Re: Substitute Consent for Quarry located at Shannapheasteen, Co.Galway

Planning Authority Report to An Bord Pleanála

Substitute Consent Application Reference Number: SU 07.SU0038

Planning Authority Reference Number: QSP 83

FIGURE 12.1 AVAILABLE SIGHTLINES AT QUARRY ACCESS ON SHANNAPHEASTEEN ROAD (taken at point 3m from carriageway edge)

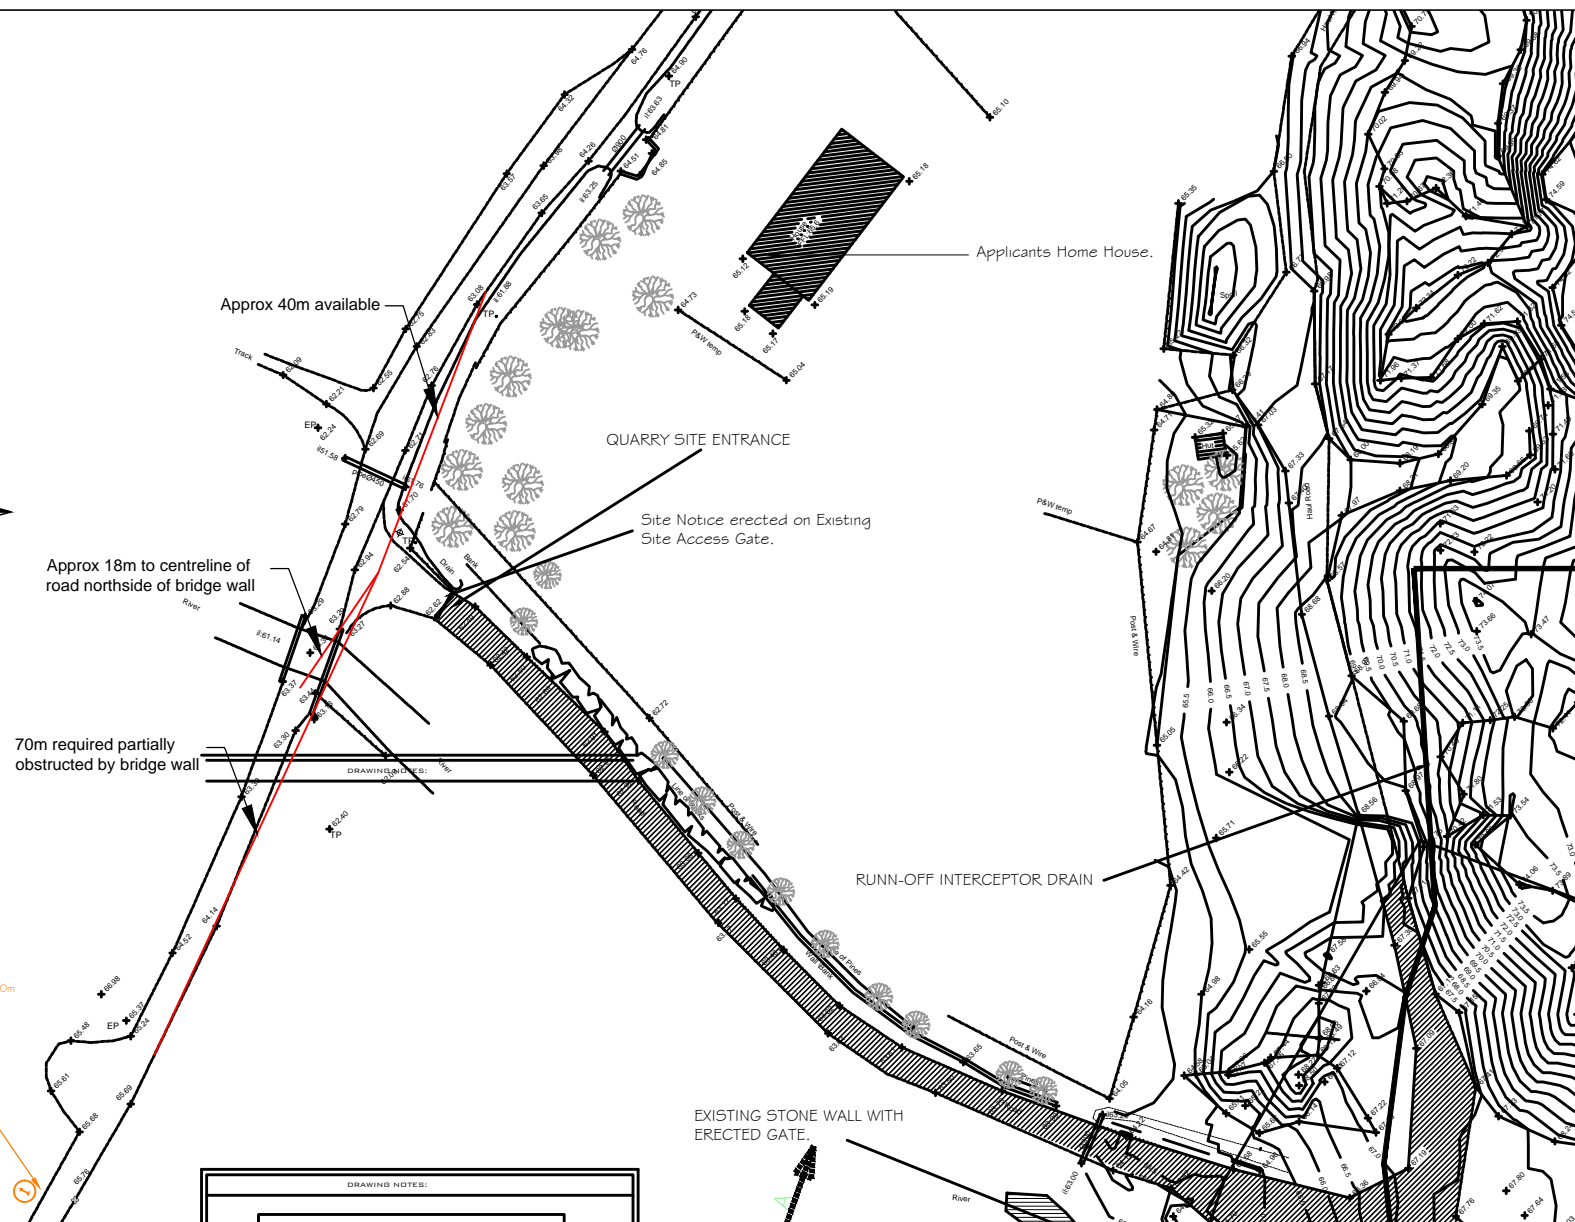
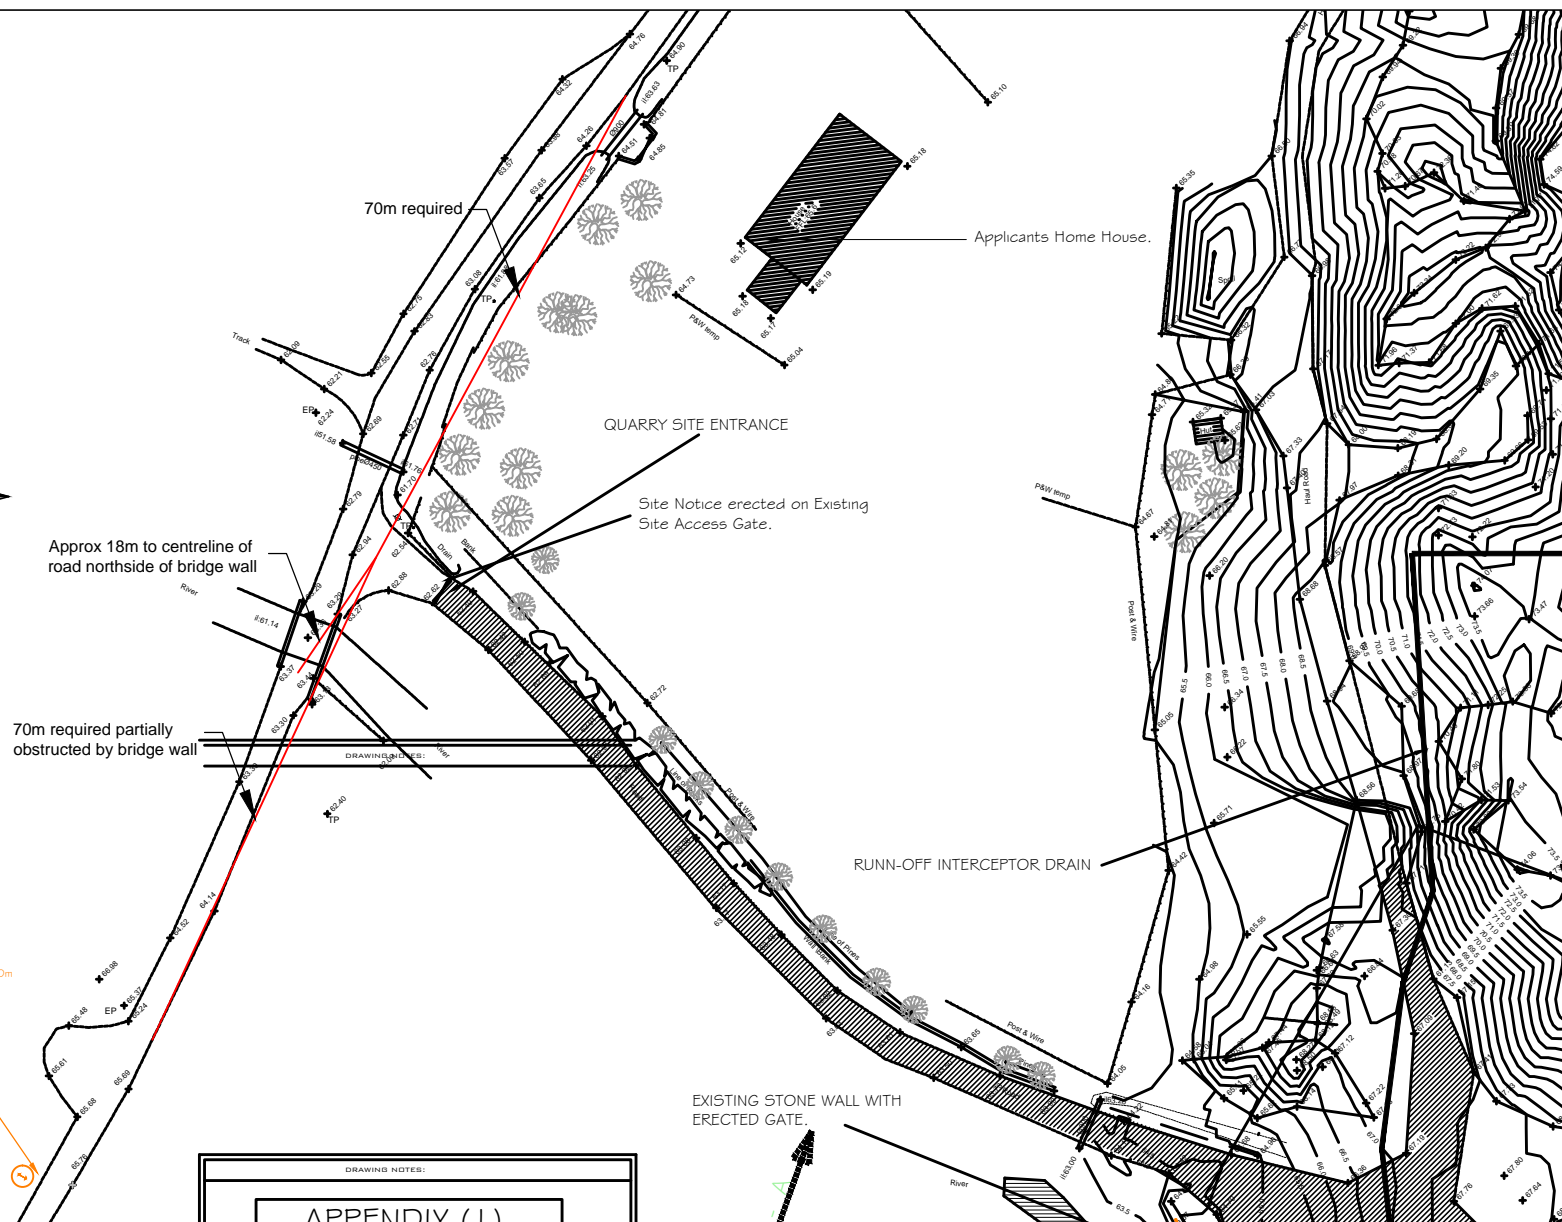
The principal concerns are the location of the entrance of the quarry access road onto the local primary road LP-1201. This entrance has very poor sight distance on both approaches with overgrown hedging to the north and a bridge parapet wall to the south. The speed limit on the local road is 80km and the appropriate sightlines should provide a minimum sight distance of 70metres on either side of the entrance.

1. Galway County Council requires that the applicant provide a minimum of 70 metres clear sight triangle set back 2.4m from the road edge at the entrance to the quarry access from the local road LP-1201.
2. Galway County Council recommend that the applicant be requested to provide a once off payment towards the upgrade of the road to the south of the quarry of €25,000 based on current proposed operations ie production of dimensioned stone. This is based on the cost of minor improvements to the pavement at specific locations on the southern approach.
3. The applicant shall agree, provide and maintain an appropriate road signage scheme to highlight the quarry entrance. This shall be agreed with Galway County Council Roads and Transportation Section.

- (6) The applicant shall provide a minimum of 70 metres clear sight triangle set back 2.4m from the road edge at the entrance to the quarry access from the local road LP-1201.
Reason: In the interests of traffic safety.
